From: Charlotte Burrows on behalf of Planning.Responses
Sent: 14 March 2012 11:36
To: Daun Johnson
Subject: FW: 24 KINGSWAY po21 4dh - AW 48 12 T - APPLICATION TO LOP TREES
Follow Up Flag: Follow up
Flag Status: Red
Attachments: 24kingswaytrees.zip

Subject: AW/48/12/TC - Lop by a minimum of 3m 14 no. Lleylandi trees at The White House, 24 Kingsway, Aldwick

Block Plan 1:500

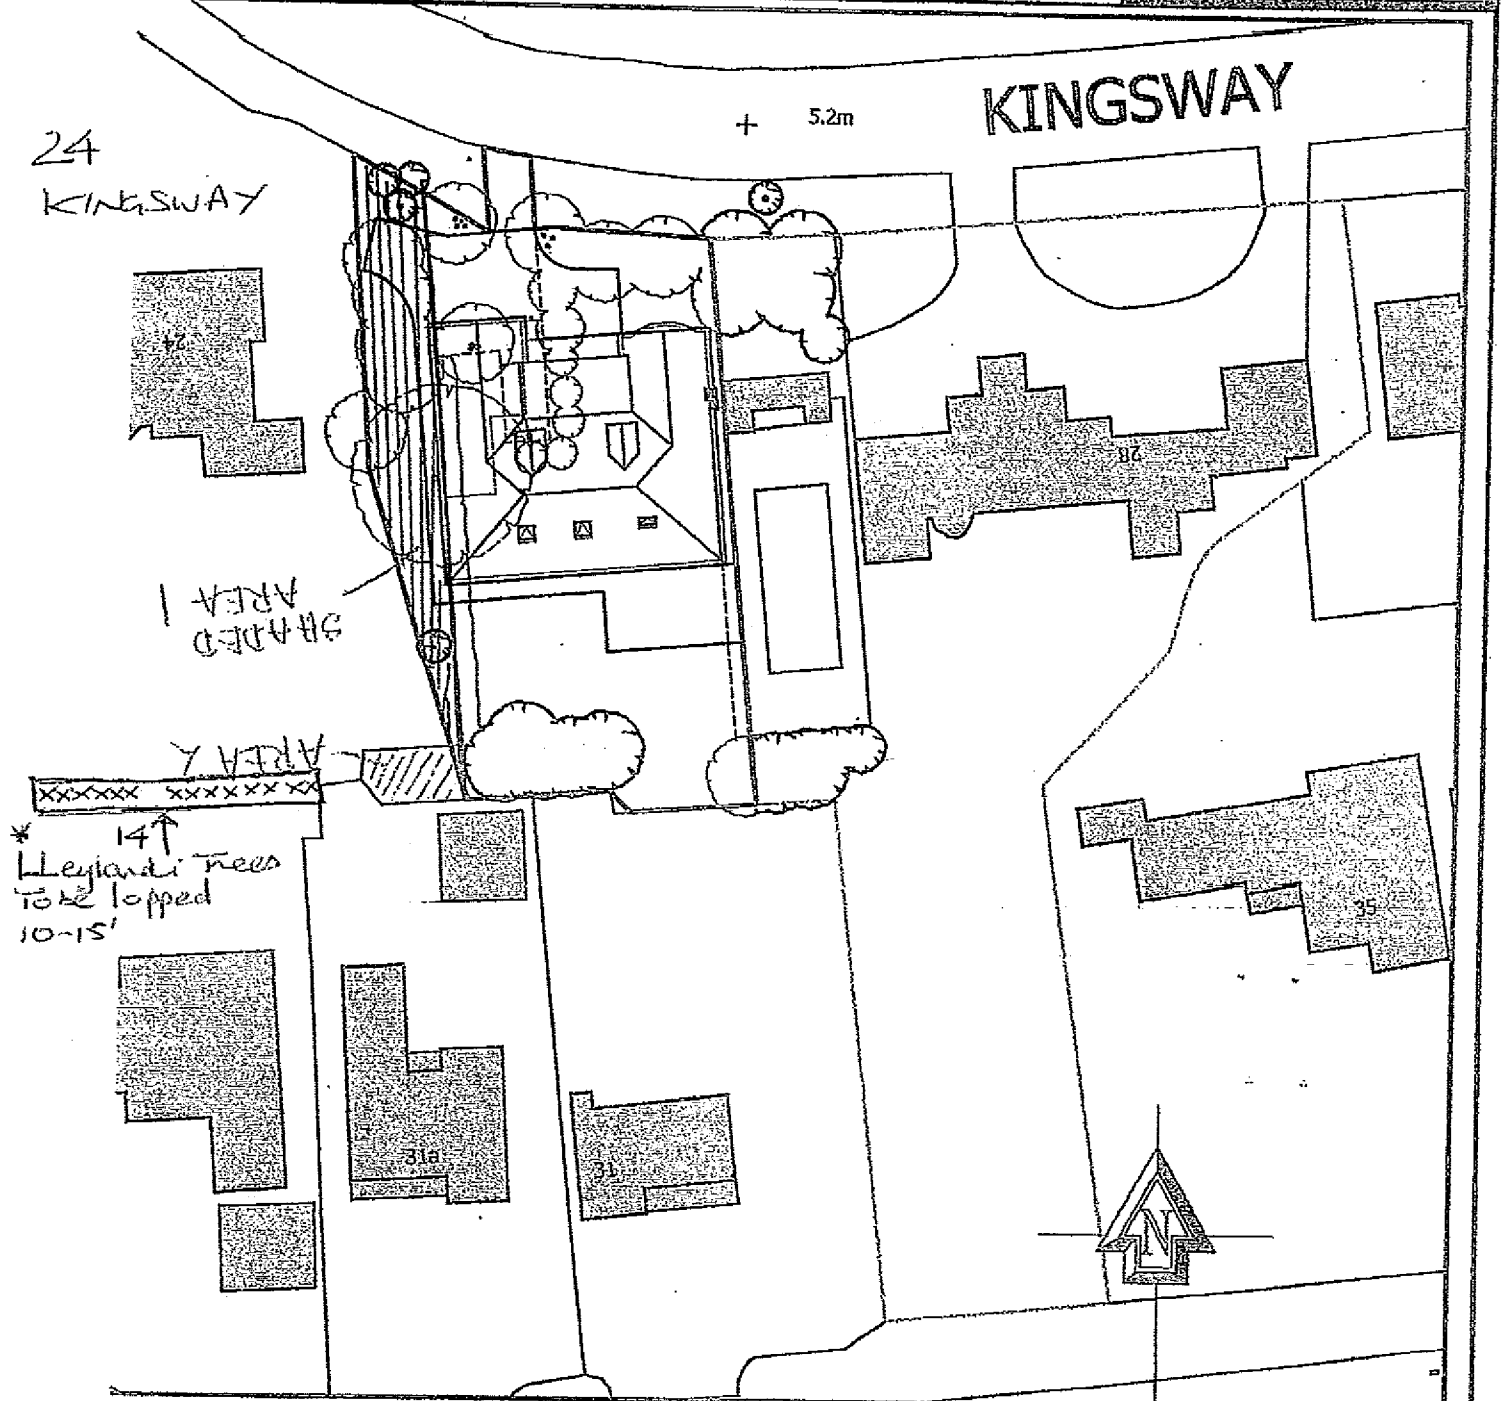
Please can you confirm the number of Lleylandi trees to be lopped as the notification under Section 7 states 15 but the submitted plan states 14.

Firstly, in Section 7 of the Application it says "lopping of minimum 10ft of 15 tall conifers.....", then in on the 'plan it states " 14 Lleylandi trees....". So which is it please???

Secondly, there are hatched areas on the plan that appear to have no relevance to the Application. I believe the plan/drawing is a simple copy of a plan that related to AW317/11 Brus Lodge, where hatchings were to do with the development/exchange of neighbouring land as part of that 'deal'. The plan has the same developers logo (HJ Concepts) and indeed the same name heading of Mr D.T.Colley of Brus Lodge.

Such duplication of plans/maps is at the least confusing if not misleading. A plan should contain only that detail pertinent to a particular application.

In my view it is pure laziness on the part of the Applicant and should be addressed by replacing the submitted plan with a more accurate set of details - 14 or 15 trees and a proper plan/drawing.
